WEST SUSSEX COUNTY COUNCIL CONSULTATION

TO:	Arun District Council FAO: M Tomalova
FROM:	WSCC - Highways Authority
DATE:	29 August 2019
LOCATION:	Nyton House Residential Home Nyton Road Chichester PO20 3UL
SUBJECT:	AL/70/19/PL Change of use from dwelling house (C3 dwelling house) to residential care home (C2 residential institutions) to provide 9 No. bedrooms, kitchen & dining & new rear sun lounge. This application affects the setting of listed buildings.
DATE OF SITE VISIT:	n/a
RECOMMENDATION:	No Objection
S106 CONTRIBUTION TOTAL:	n/a / £ See below for breakdown.

Proposed Site Plan
1 : 100

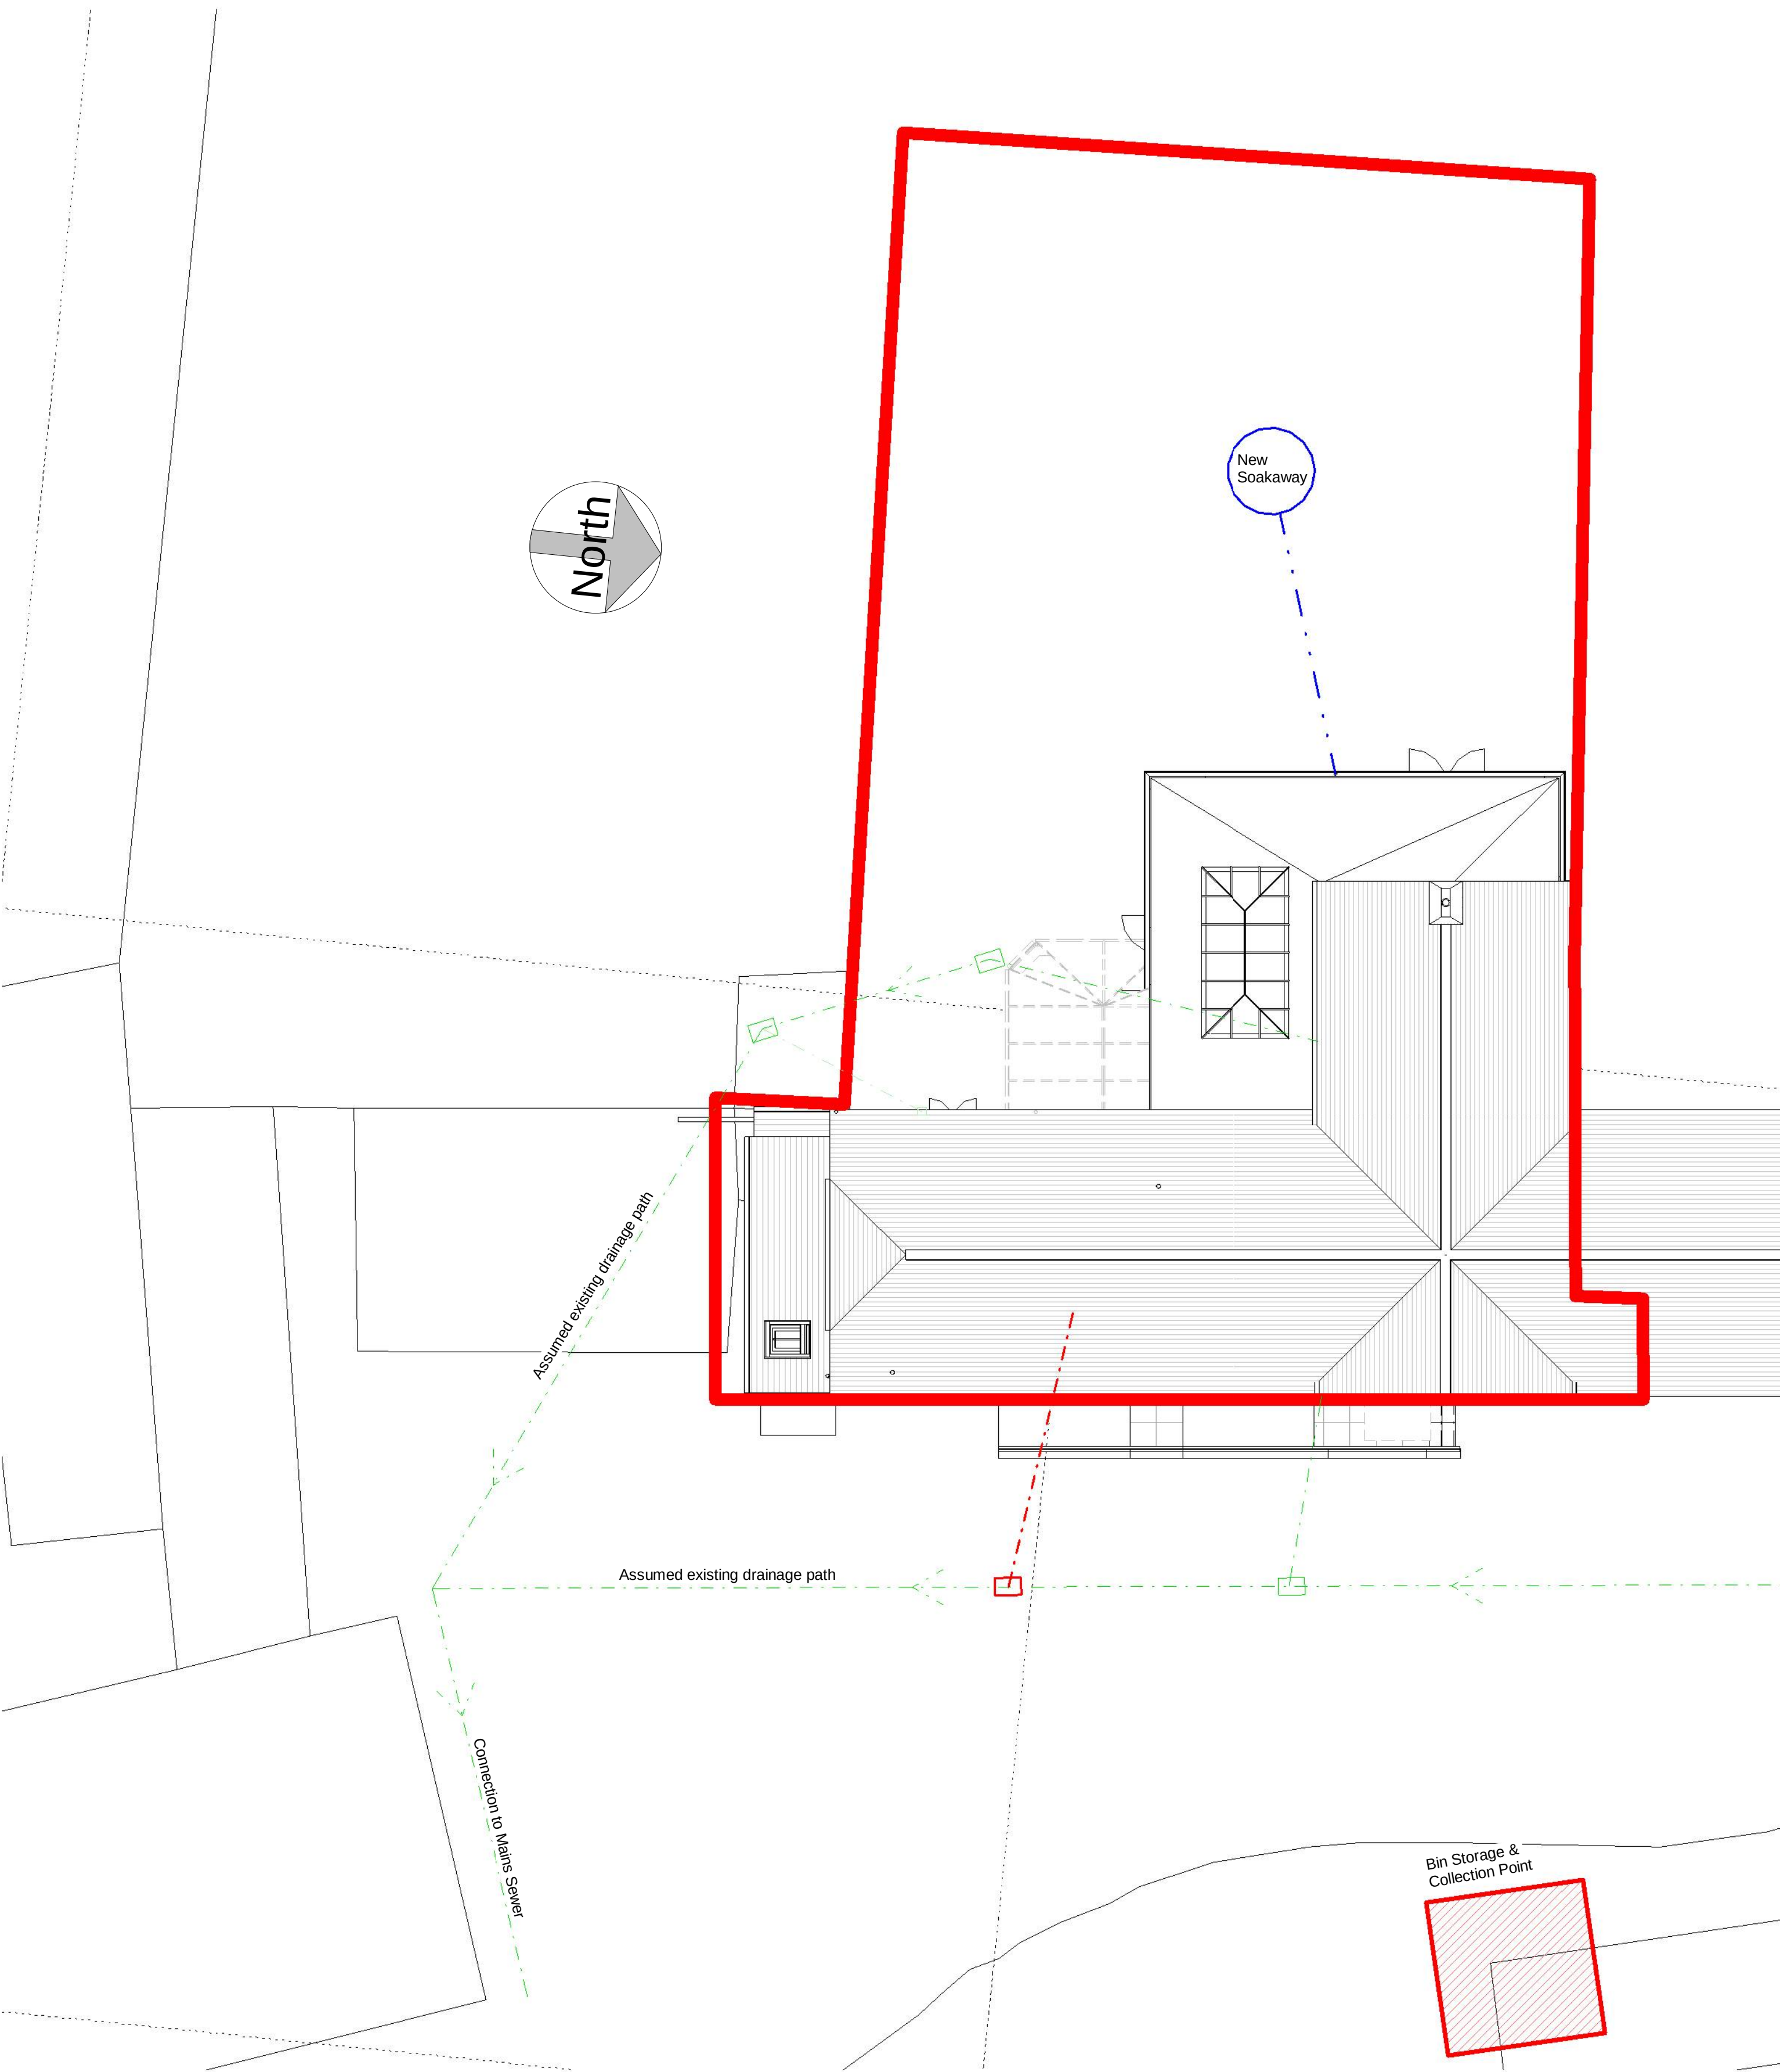
Car parking for the use has not been included in the application. It is considered there may be a requirement for additional parking however; more information is required and should be submitted to the LPA for approval, to ascertain what is already available to determine if more is needed.

Car parking space (details required)

No part of the development shall be first occupied until the car parking spaces have been constructed in accordance with plans and details to be submitted to and approved in writing by the Local Planning Authority. These spaces shall thereafter be retained at all times for their designated use.
